From: D HARRIOTT [REDACTED]
Sent: 08 November 2011 11:42
To: Anita Gardner
Subject: Re: LY/19/11 - Alterations to dwelling under construction. Amendment to approval LY/19/11.
 Thelton House, Crossbush Lane

From: Anita Gardner <Anita.Gardner@arun.gov.uk>
To: [REDACTED]
Sent: Tuesday, 8 November, 2011 10:22:00
Subject: LY/19/11 - Alterations to dwelling under construction. Amendment to approval LY/19/11.
 Thelton House, Crossbush Lane

SITE PLAN — AS PROPOSED
1:200 @ A1

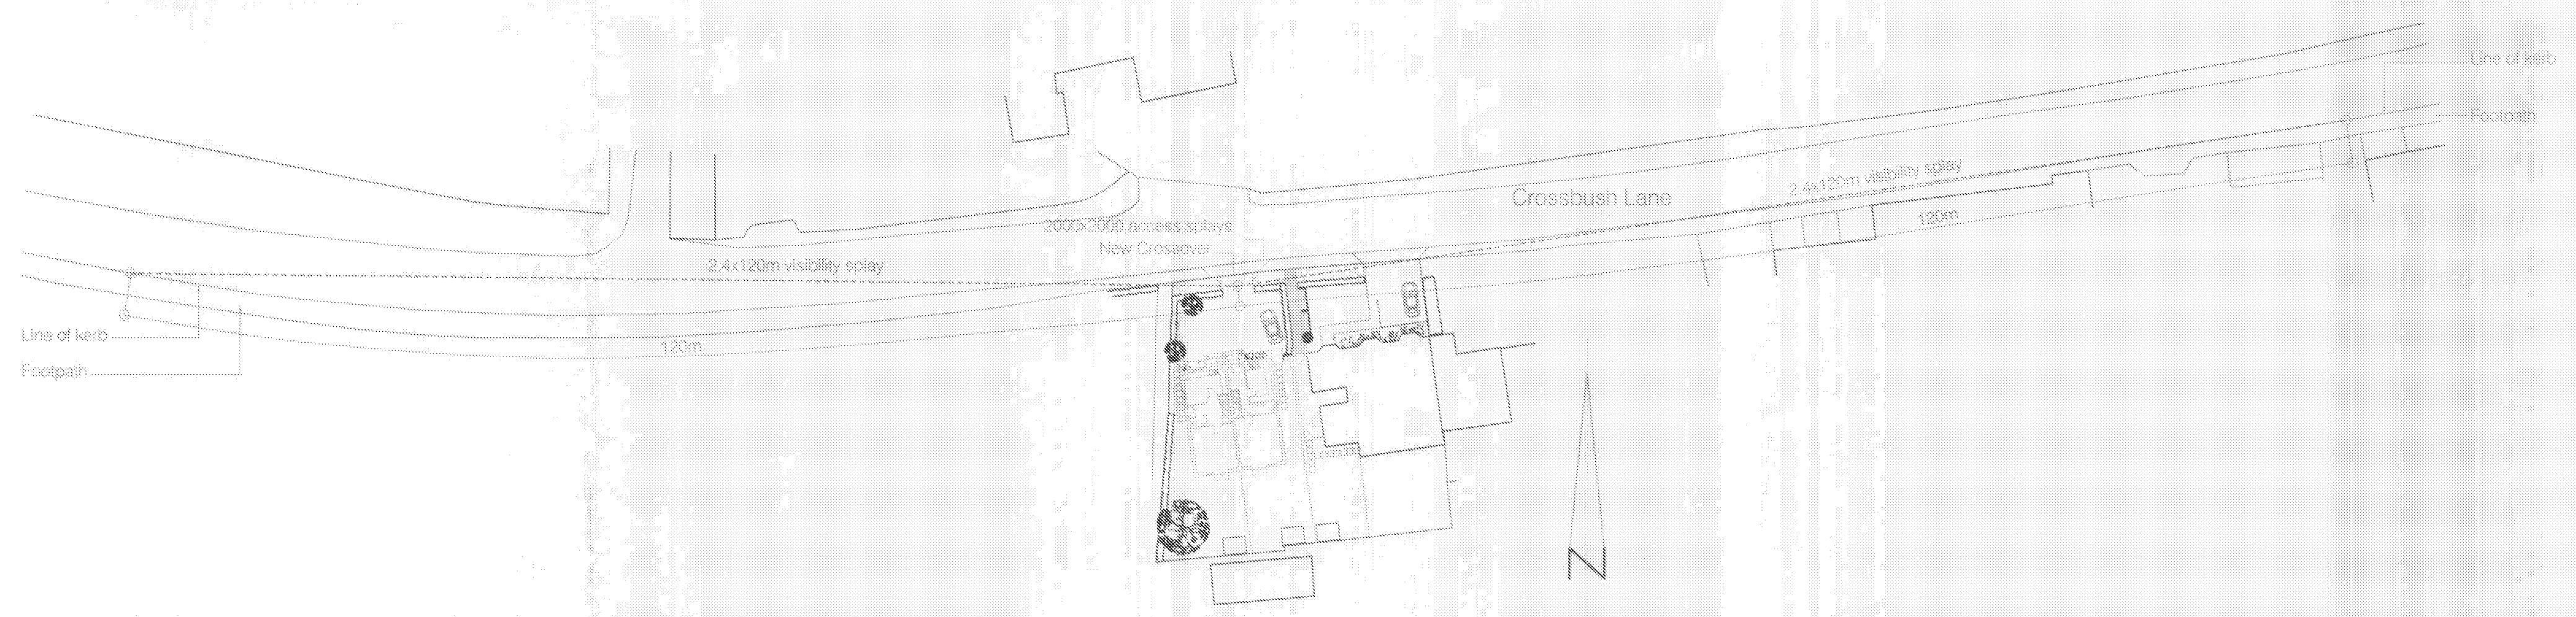
I would like the letter treated as a neutral comment. However the Council would still like record made re the importance of the car parking area at the front of the house being installed so as to avoid parking on Crossbush Lane where parking space is at a premium.
